Building

Energy

**CRAWL SPACE VENTILATION COMPLIANCE**

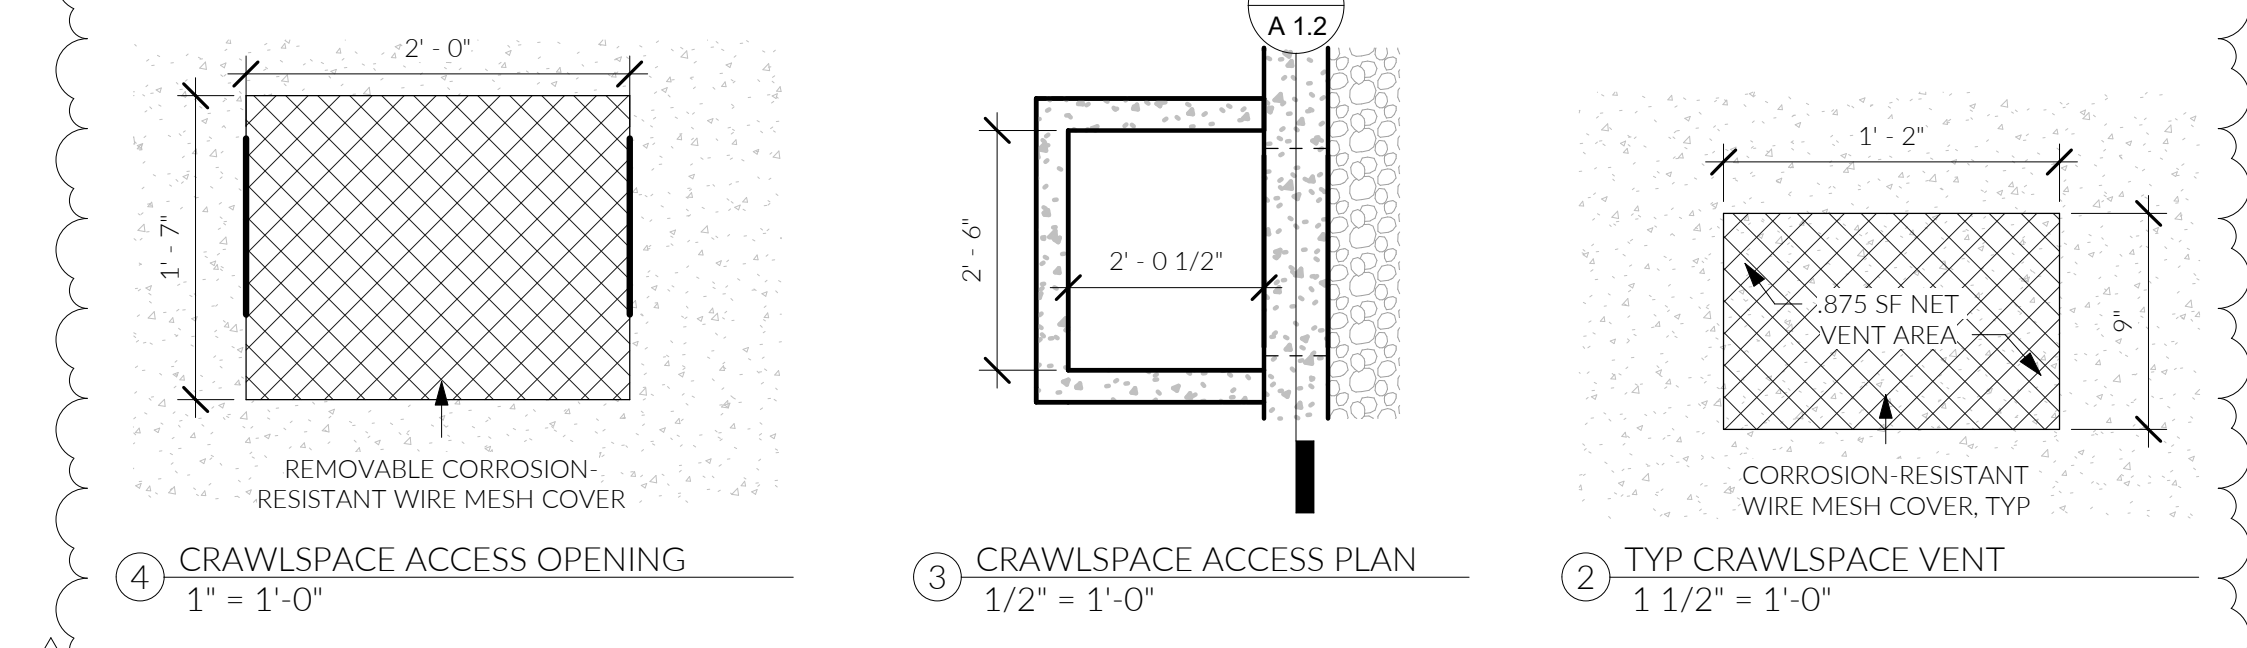
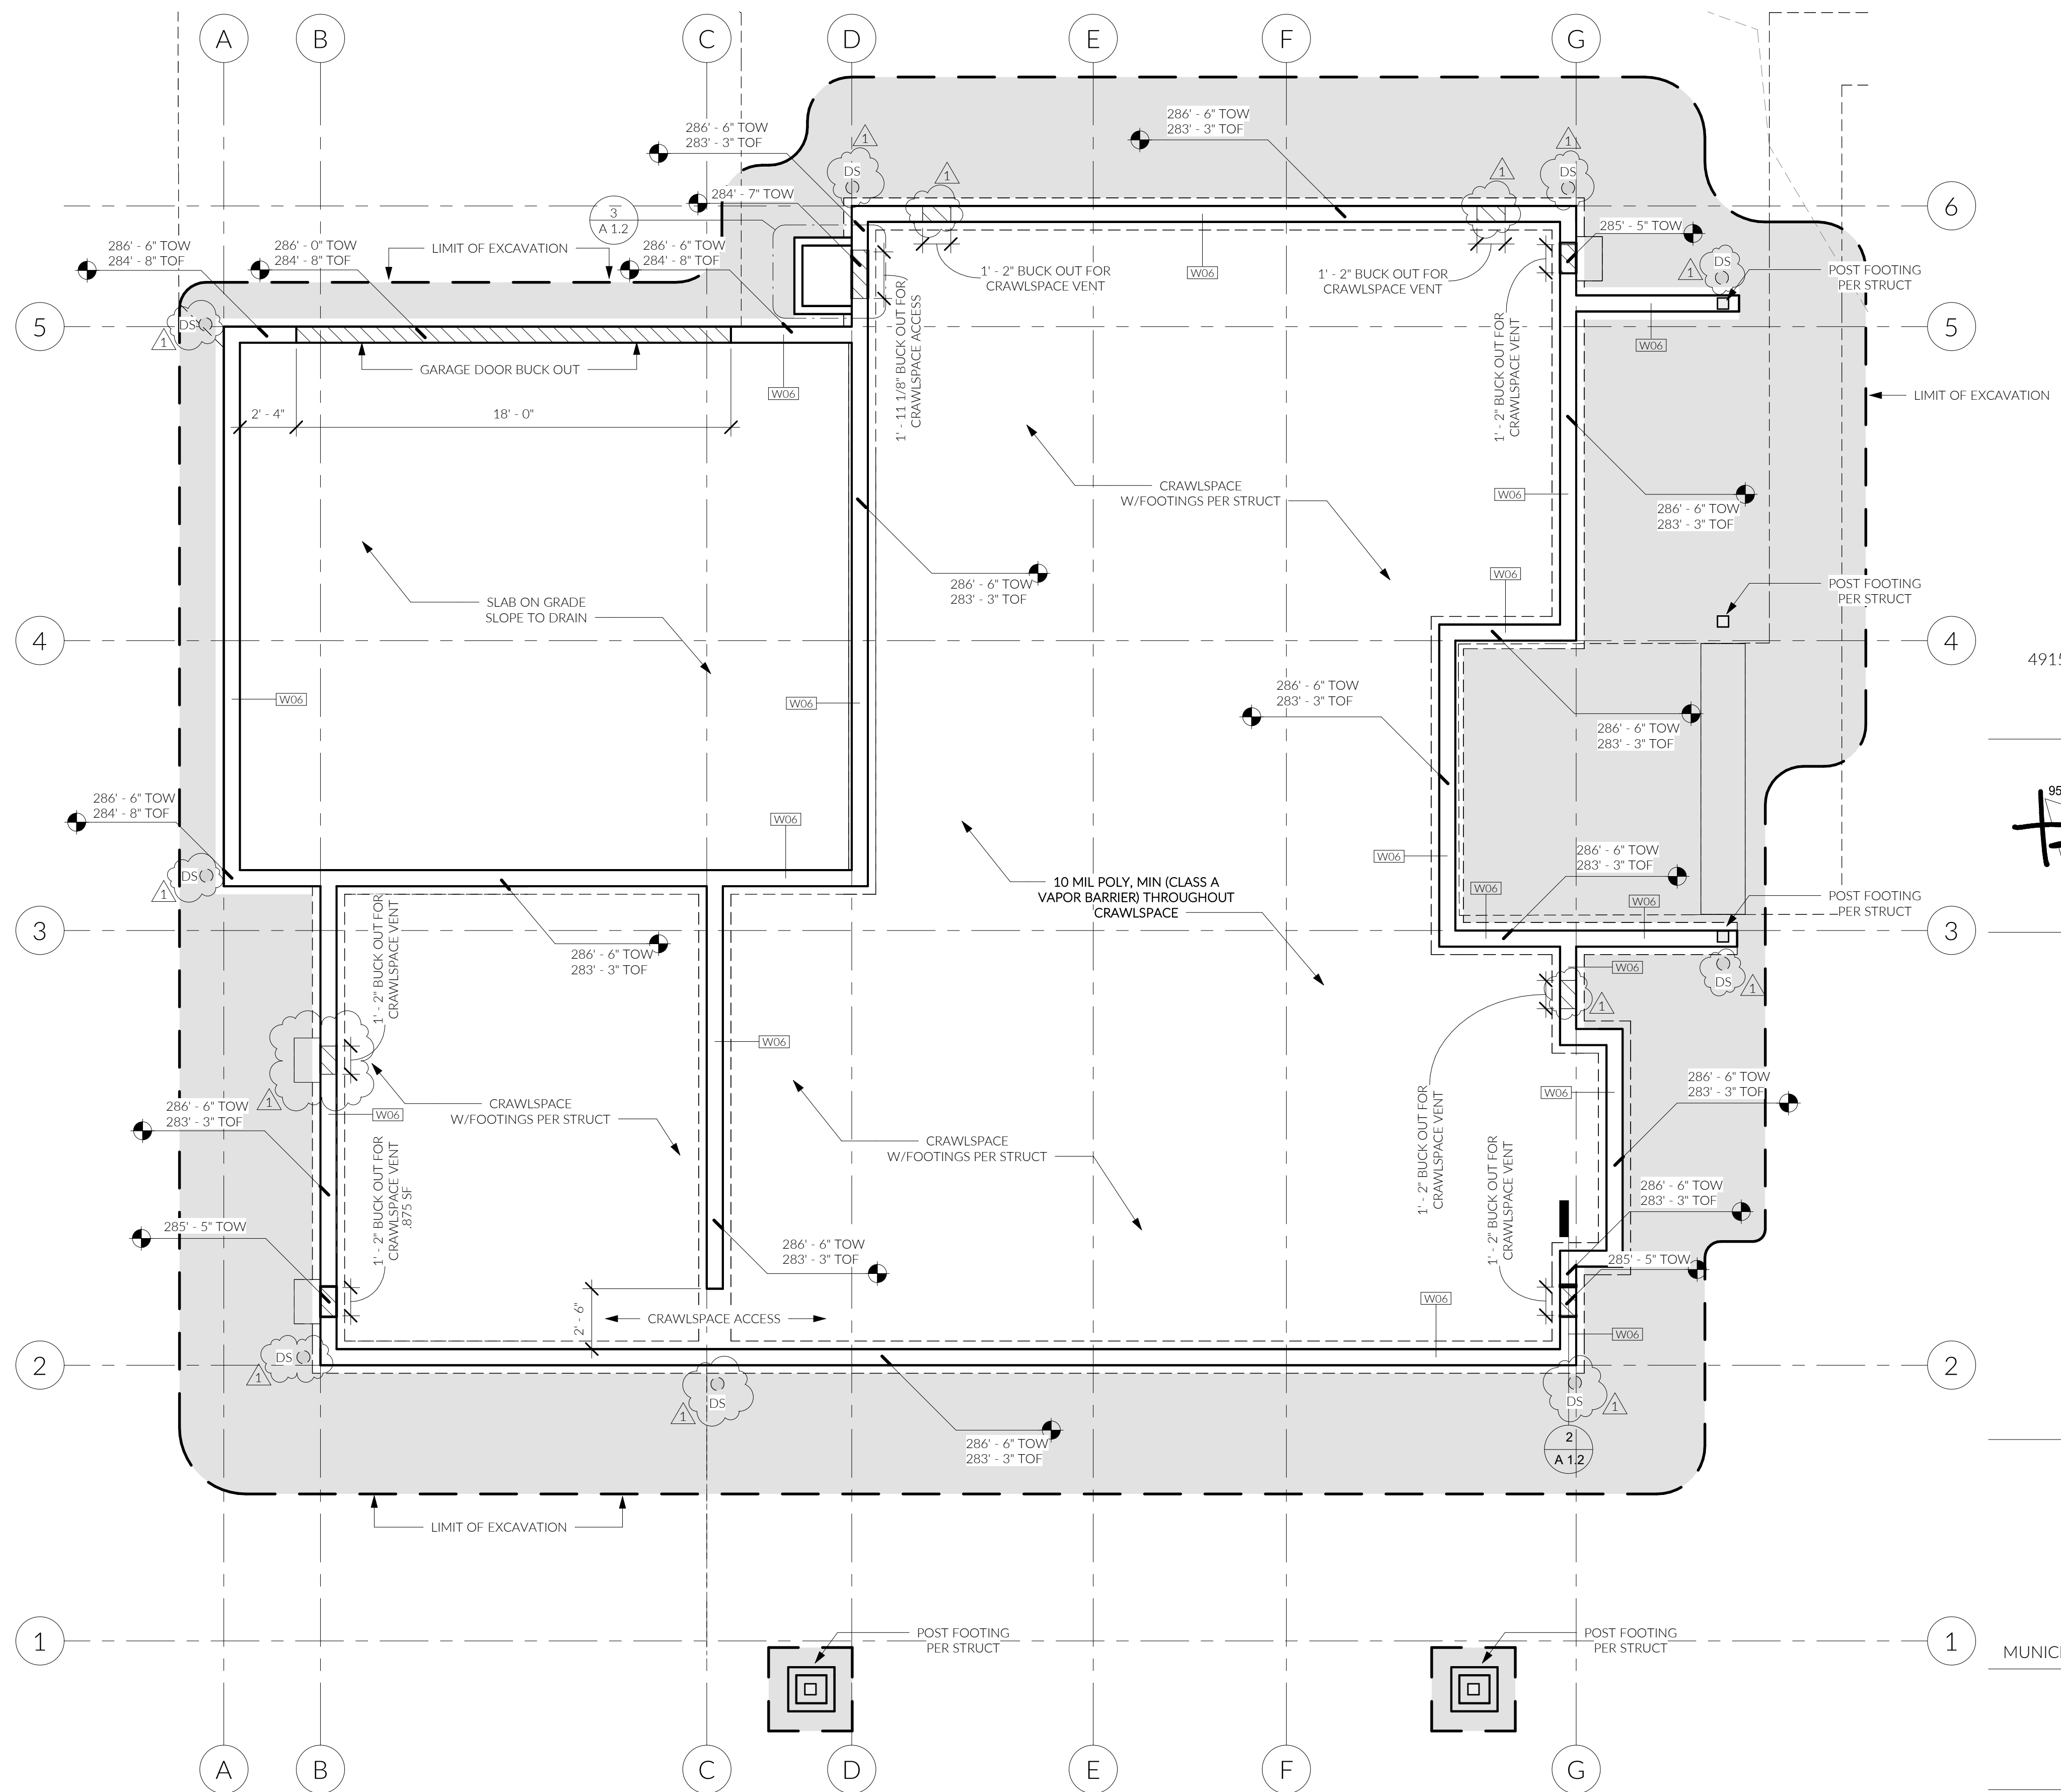
- 1.) The crawl space ventilation calculations on Sheet A1.2 were revised to use a net ventilation area of 1:300...
/// Notes revised for 1:300 ventilation in crawlspace. Please see sheet A1.2.

- 2.) The net ventilation area needs to be considered per IRC R408.2 when determining the required ventilation. Typically, the mesh allows a net area of 75% of the gross opening area. The added details on sheet A1.2...
/// Dimensions and details revised to account for 75% net area at openings with mesh. Please see sheet A1.2.

- 3.) Crawl space access is required per IRC R408.4 to be 16" x 24" through walls. The exterior access opening is called out in plan with...
/// Plan dimension revised to show 24" width per detail 4/A1.2. Please see sheet A1.2.

1 A - ROOF PLAN  
 1/4" = 1'-0"

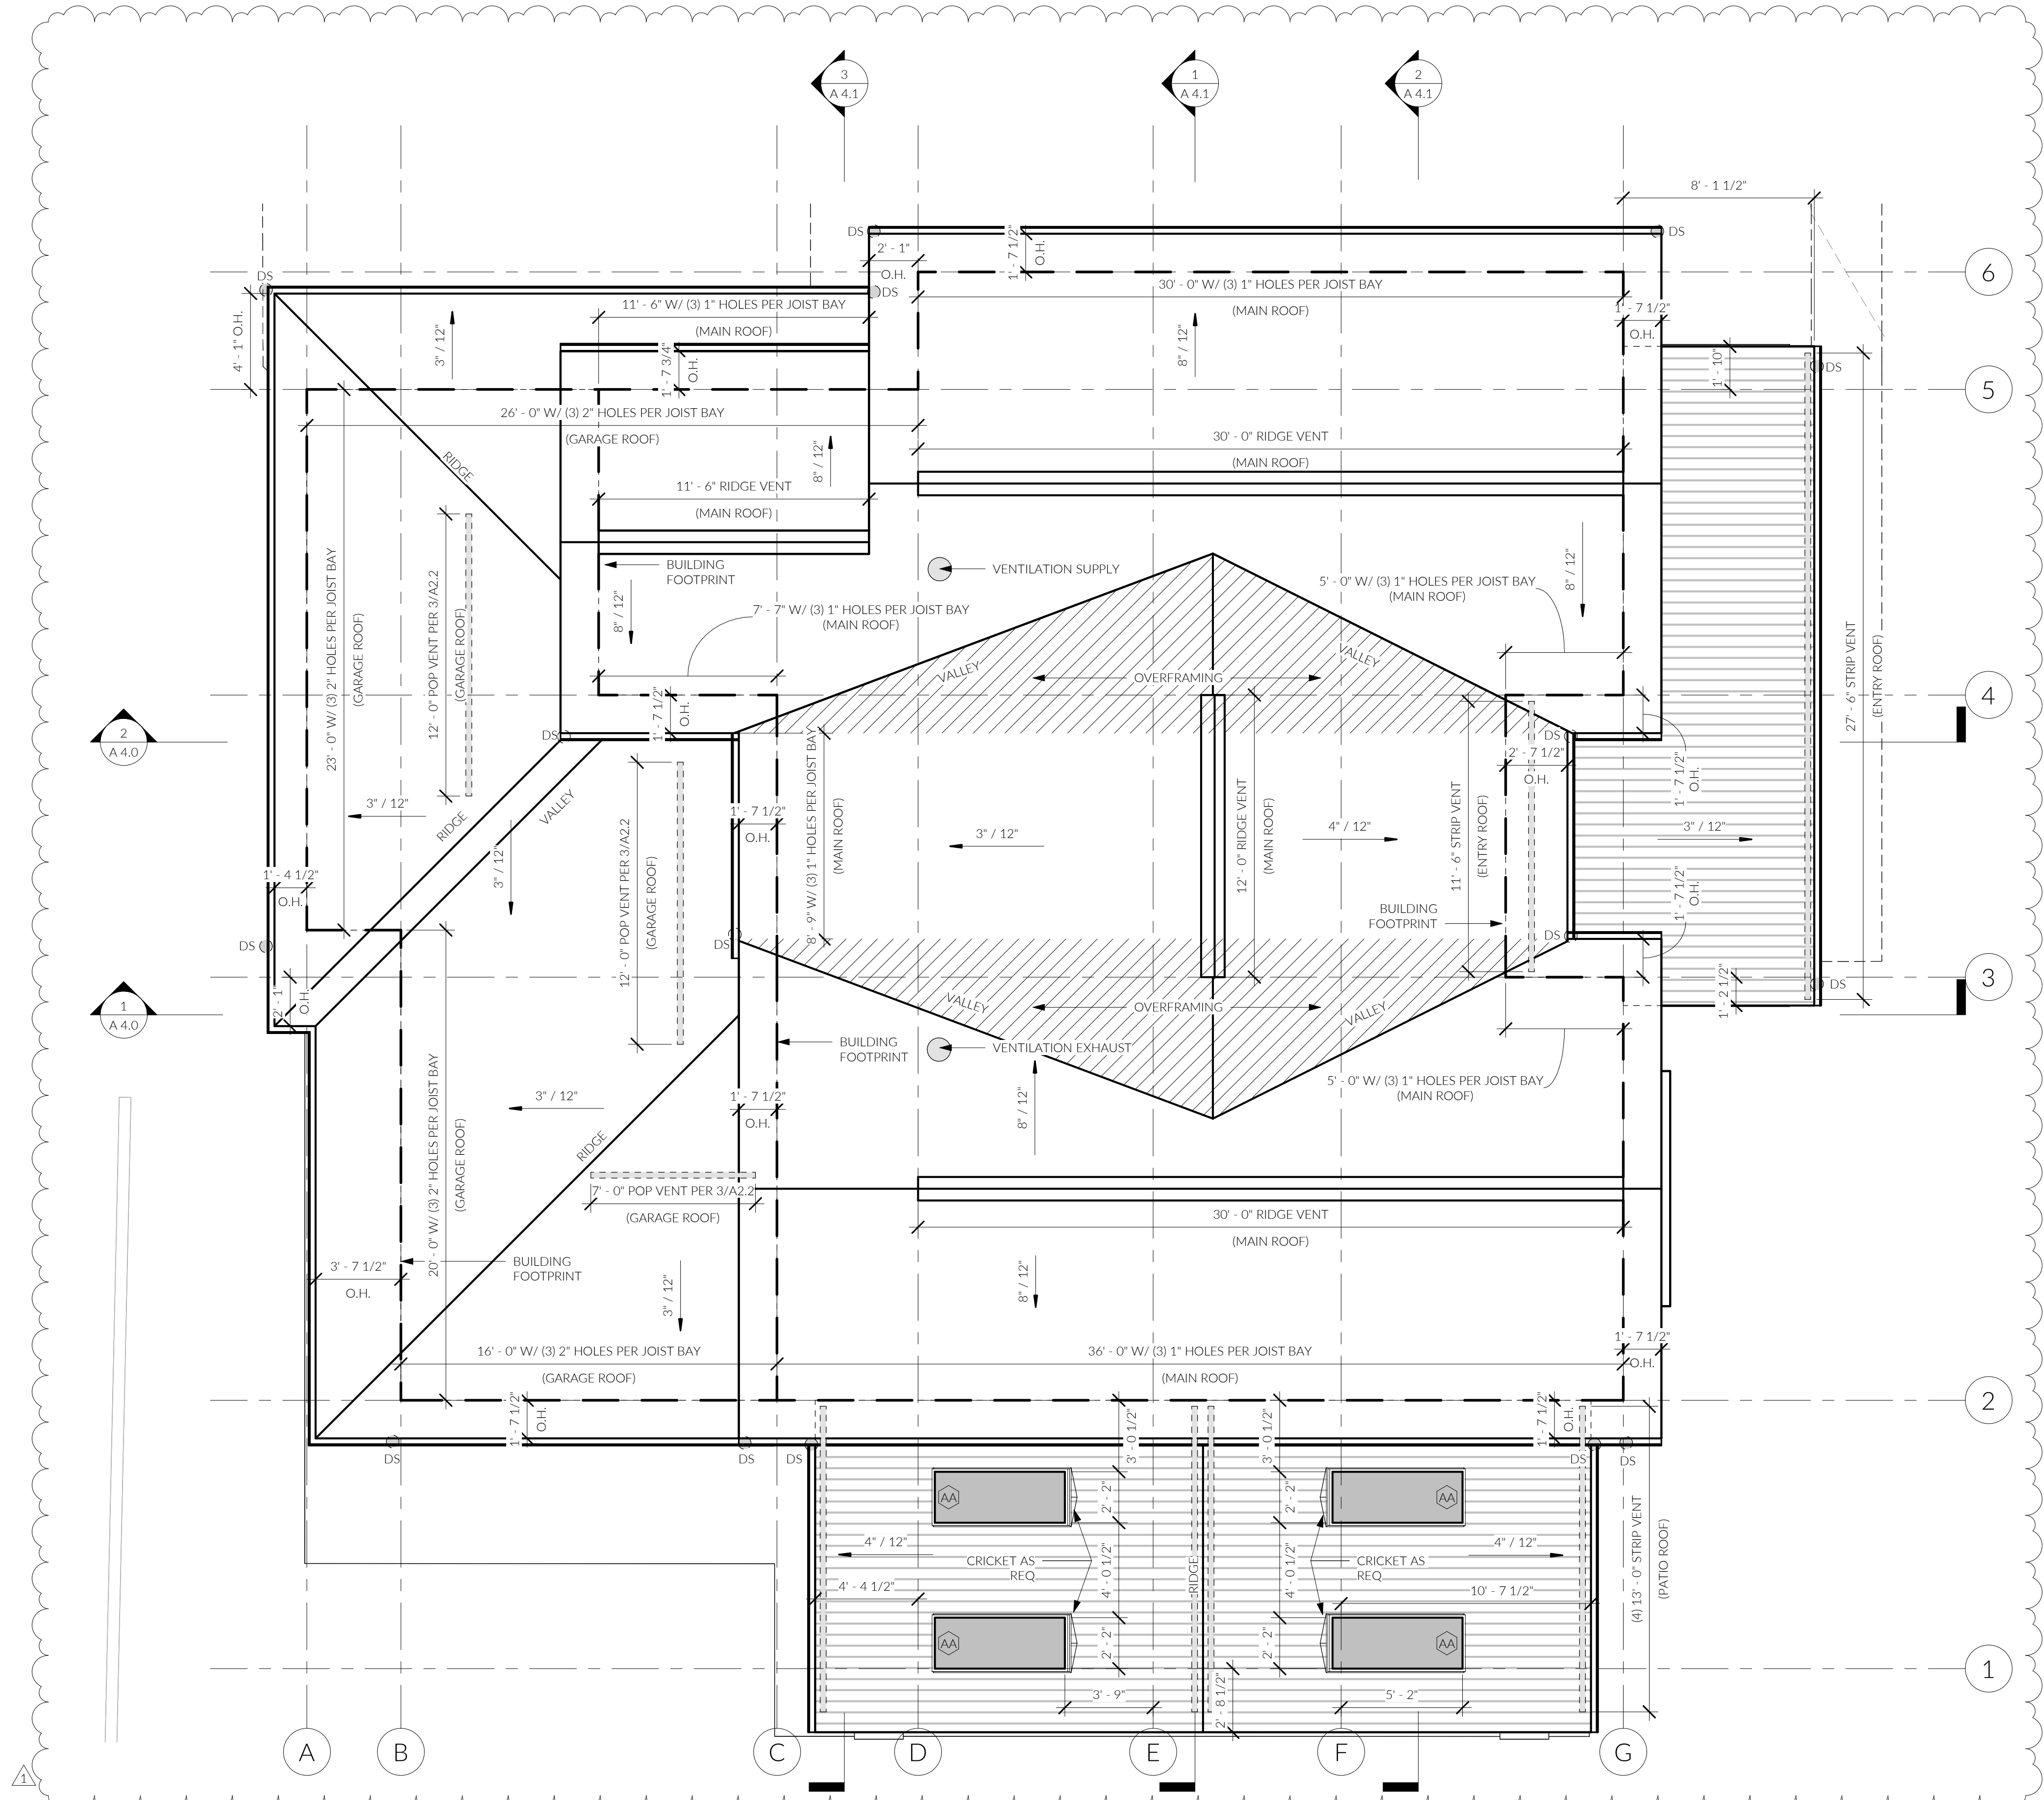
- 5.) Enclosed attics and rafter spaces must have cross ventilation for each space per IRC R806.1. The minimum net free ventilating area of 1:150 must be provided unless the provisions of the exception to IRC R806.2 are met.
*/// a) Calculations updated to account for 75% net area at openings with mesh.
/// b) Calculations updated to reflect 24" on center framing.
/// c) Strip venting detail added. Please see detail 4/A2.2.*
